Our Ref: EP/39/26/NMA

Non material amendment following the grant of EP/104/24/HH to increase width to the proposed detached car port.

16 Sea Lane East Preston BN16 1NG

Drawing Name:
Proposed Block Plan

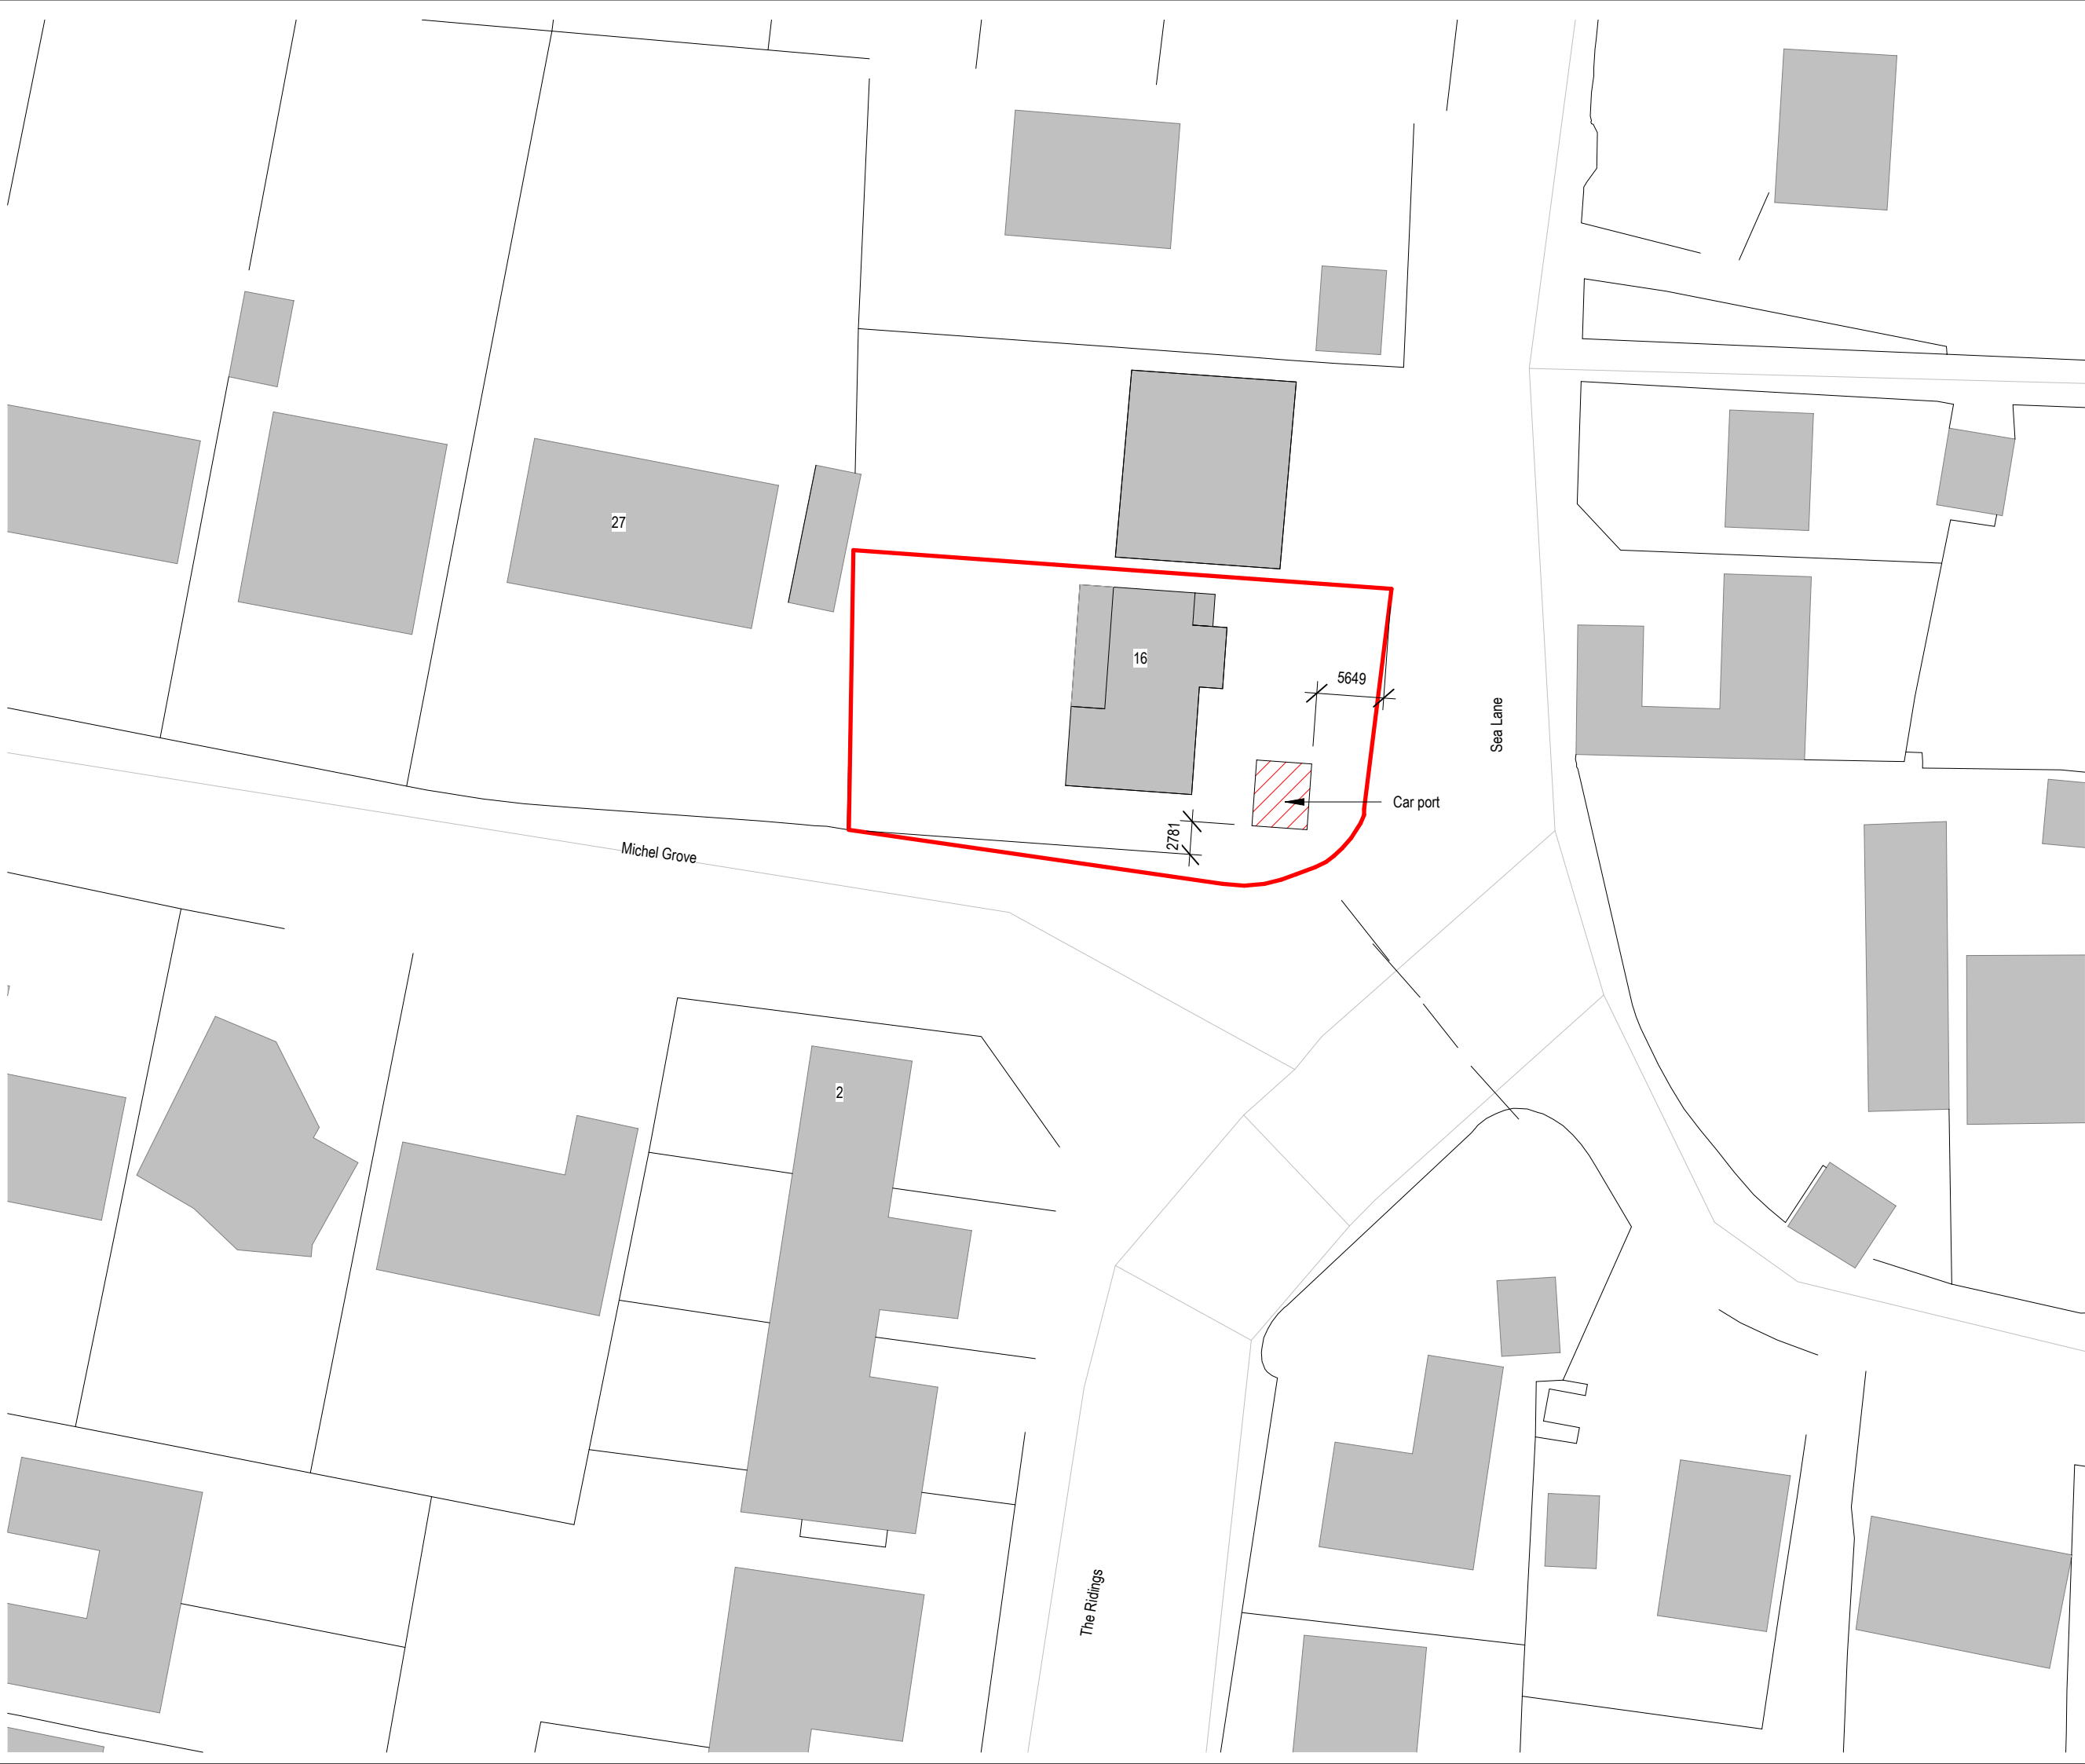
The proposal seeks to increase the size of the approved carport by 1m in width, moving the bulk of the car port towards the front elevation of the host dwelling, resulting in no impact on neighbouring residential amenity. The design and materials proposed under this amendments would continue to deliver the original design of the development. The changes are therefore considered to be minor in nature and can be determined as an NMA under section 96A of the Town and Country Planning Act 1990.

EP/104/24/HH. The new Block Plan P002 P3 and the new Roof Plan, Floor Plan, and Elevations P012 P2 are therefore accepted as part amending the previously approved Car Port Elevations P012 Rev1 and Proposed Block Plan P002 Rev2.
